**KIRKLEES COUNCIL
TOWN AND COUNTRY PLANNING ACT 1990
HIGHWAYS DEVELOPMENT MANAGEMENT**

PLANNING REF 2018/62/93906/E0/SL
CATEGORY Minor

PROPOSAL DEMOLITION OF
BARN/WORKSHOP AND ERECTION
OF DETACHED DWELLING WITH
ATTACHED GARAGE

LOCATION 4-5, MAZEBROOK,
DRUB,
CLECKHEATON,
BD19 4BT

Title Proposed Site Layout							
Client Mr & Mrs T. Skirrow							
MWA Project Ref 6198	Scale 1:200	Original Paper Size @ A1	Paper Orientation Landscape	Drawn MW(J)	Checked		
File Identifier Project	Originator	Volume	Level	Type	Role	Number	Revision
TSDL - MWA - 01 - GF - DR - A - 0005 B

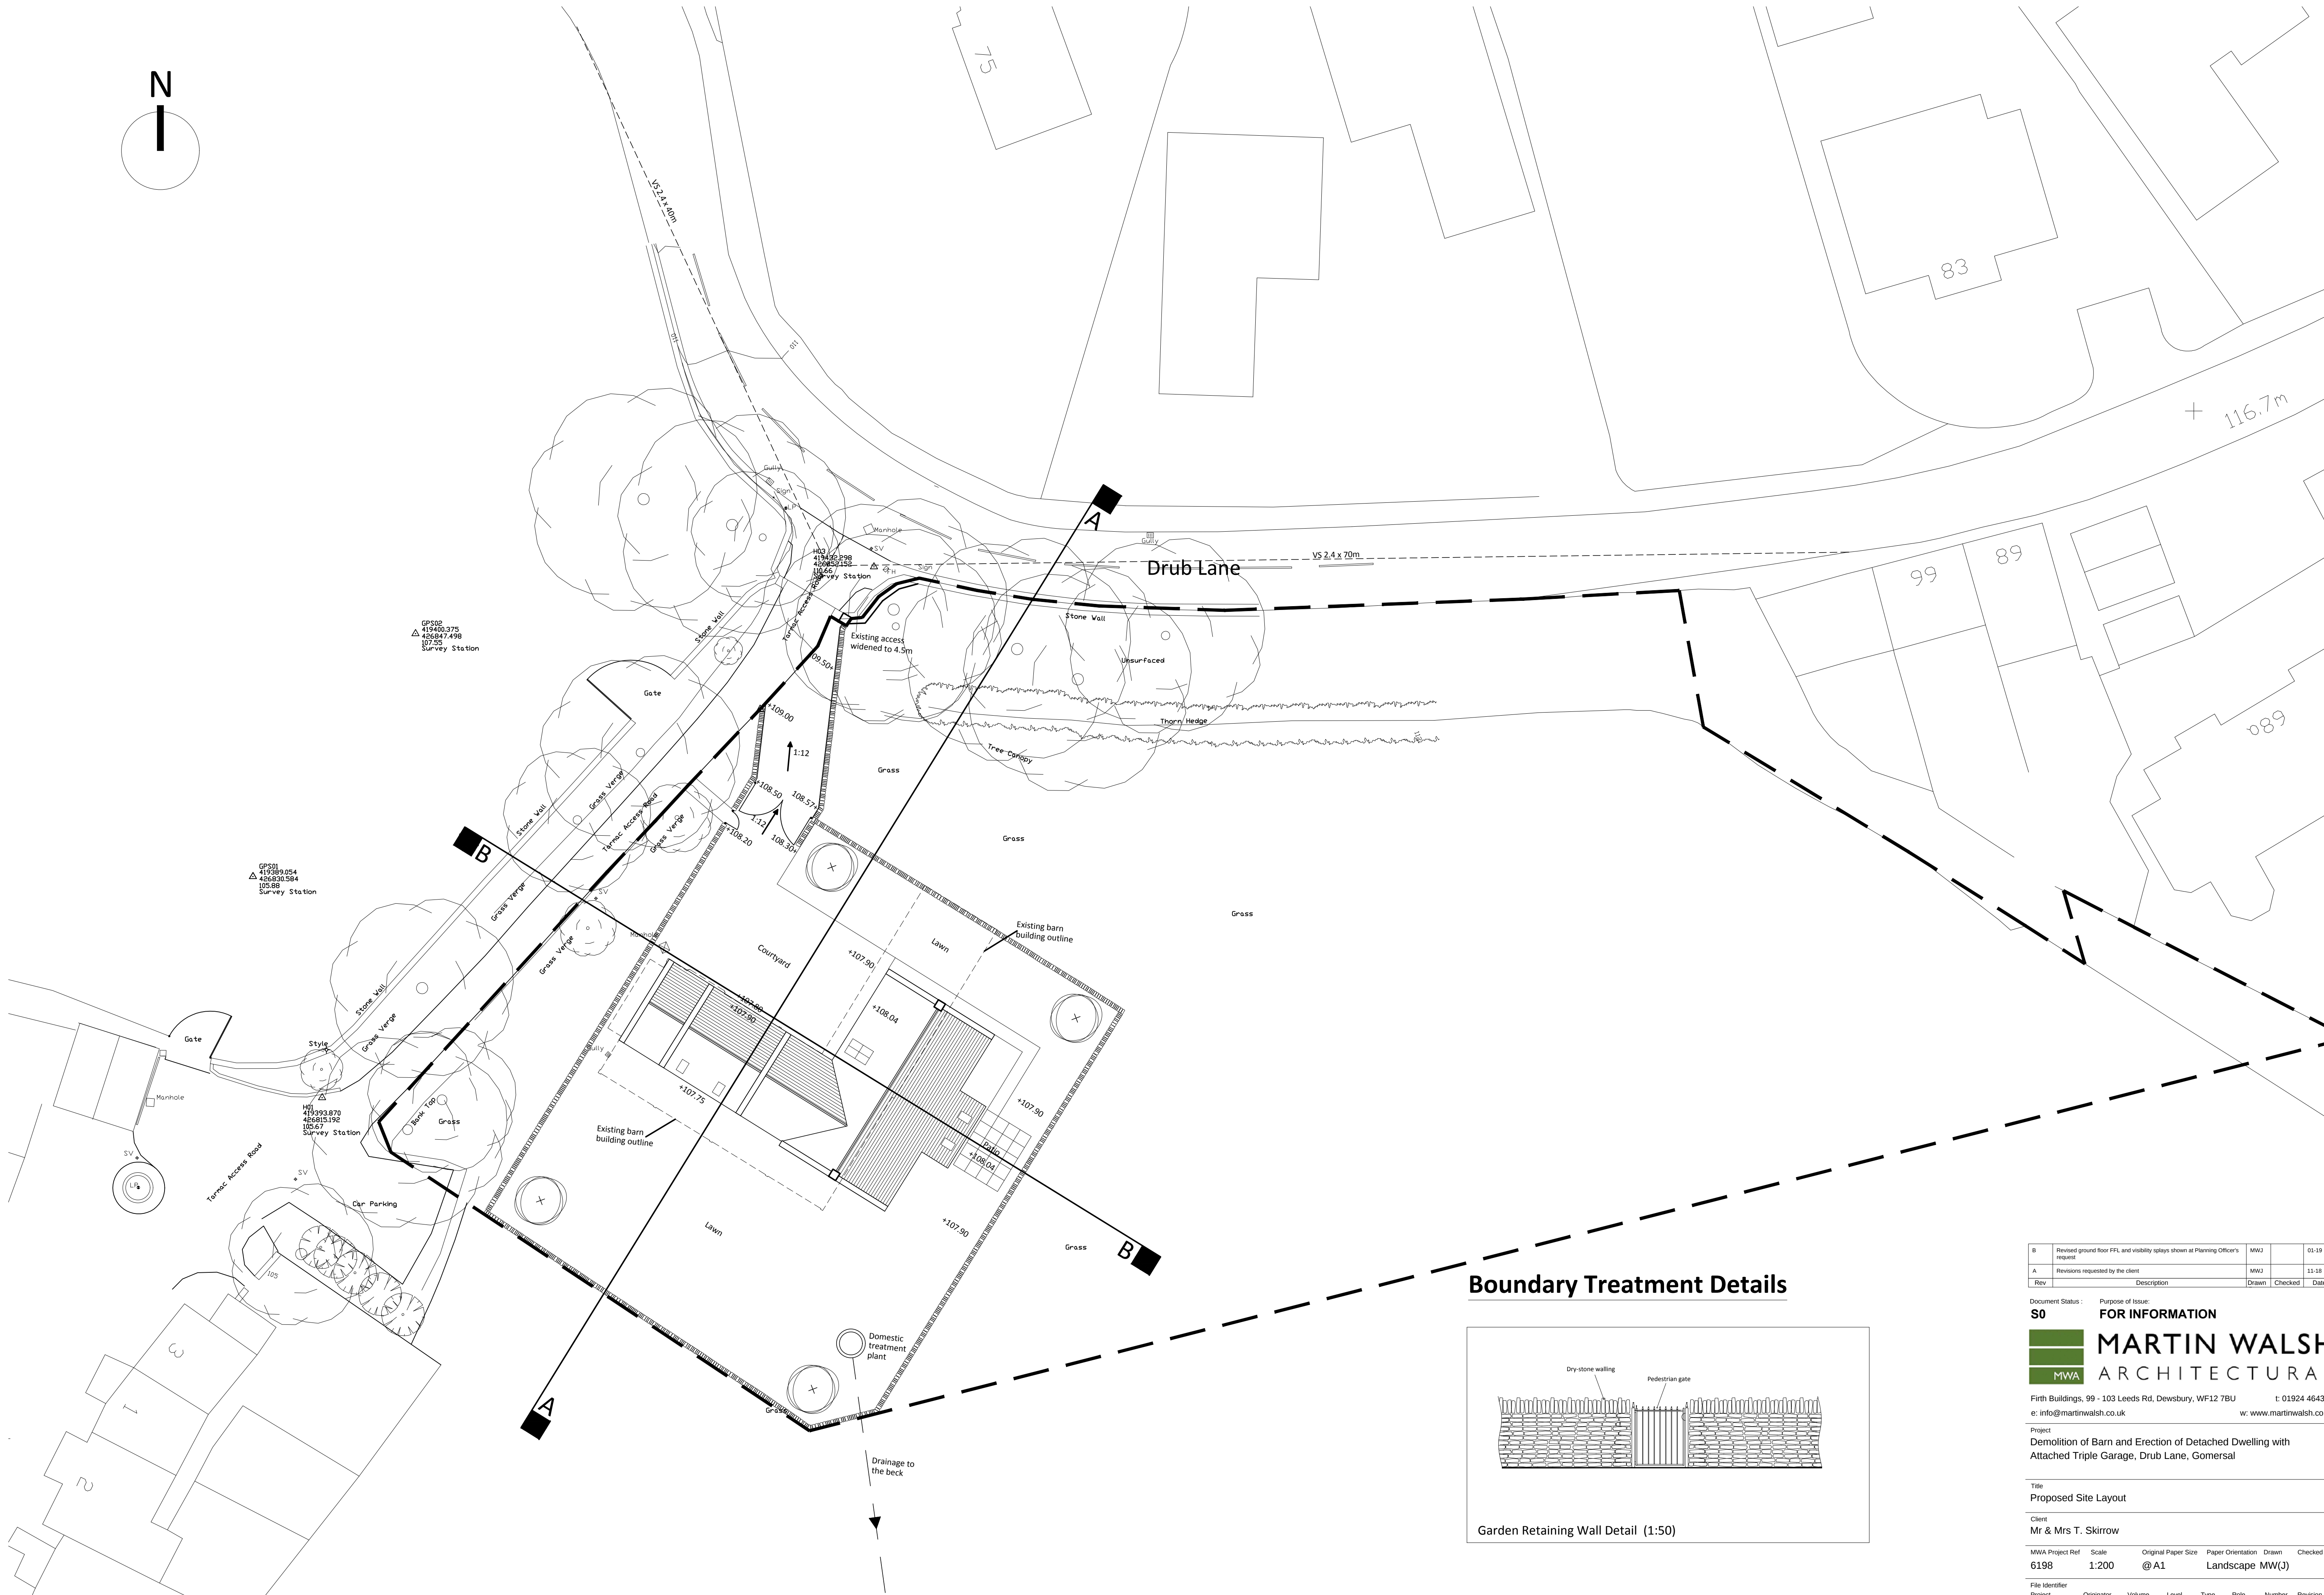
Sight lines onto Drub Lane have not been demonstrated on a suitable plan, however it is considered that this should be achievable so would request that this information is provided to remove the need for a condition.
